GRADING & EROSION CONTROL PLANS MAYBERRY, COLORADO - FILING NO. 4

EPC STORMWATER REVIEW COMMENTS
IN ORANGE BOXES WITH BLACK TEXT

GESC COVER SHEET

NO. C8.1

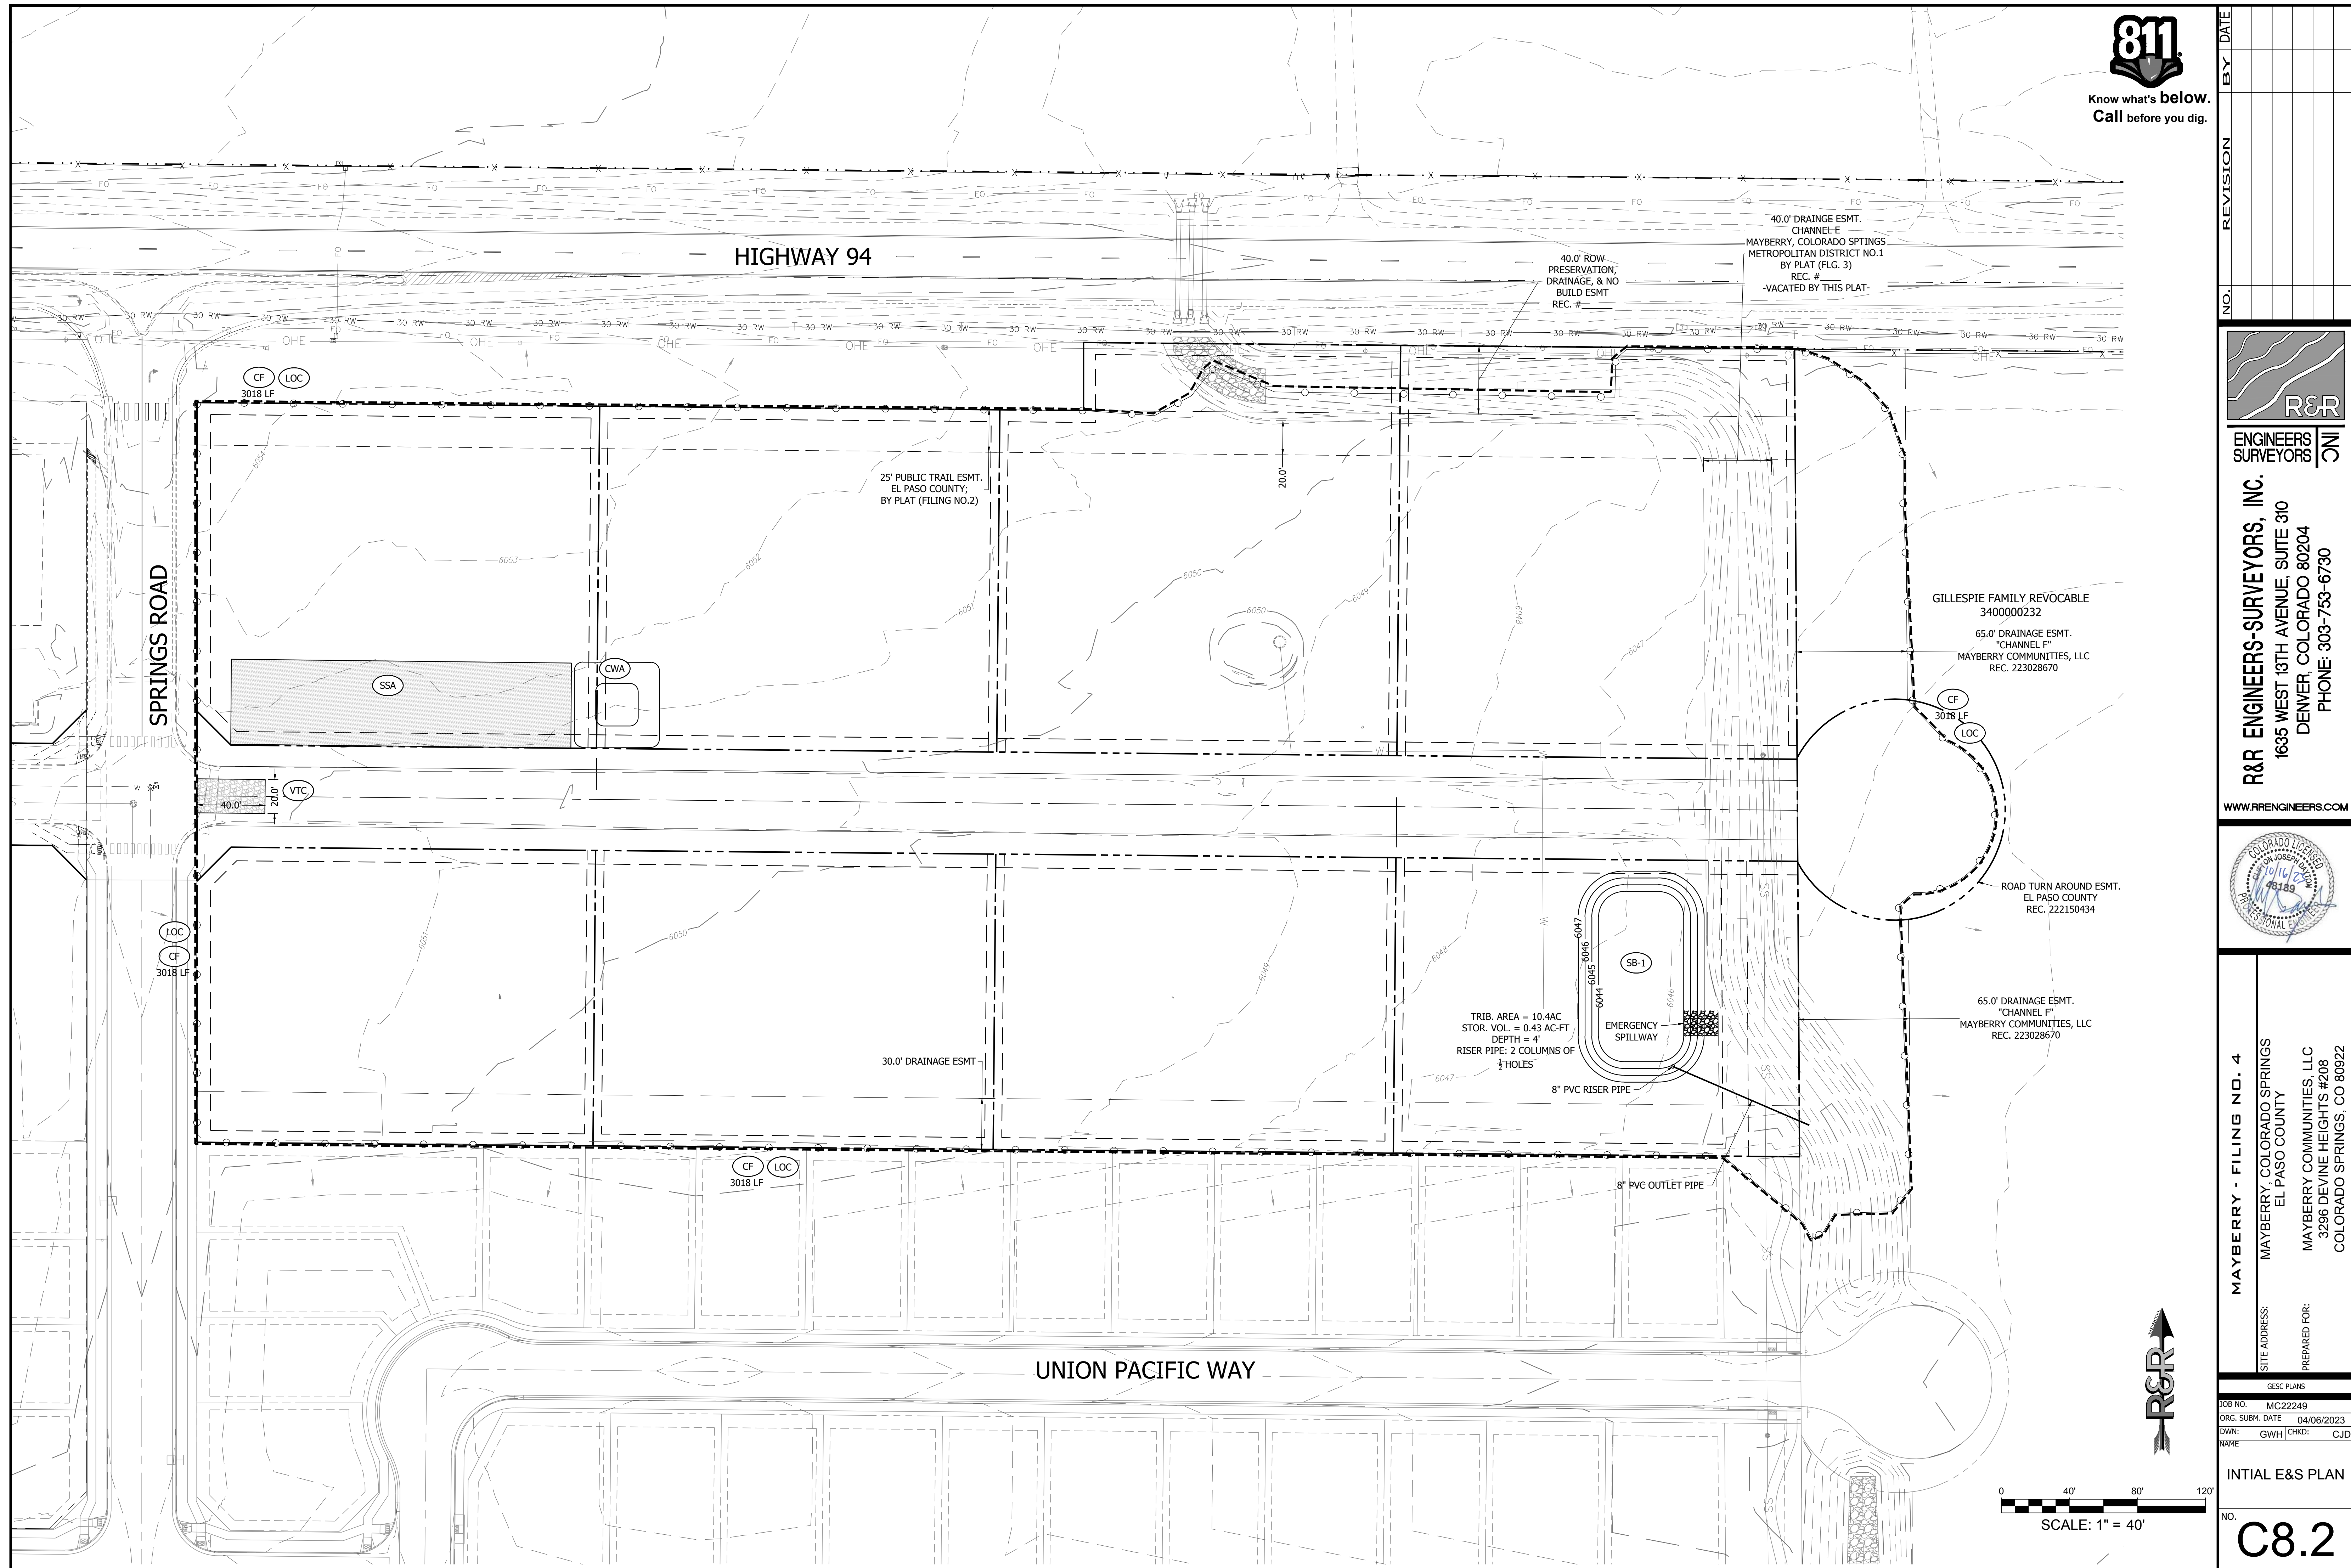
To comply with SWMP Checklist Item 17i: Please add a note stating there are no stream, wetlands, or other surface water crossings.
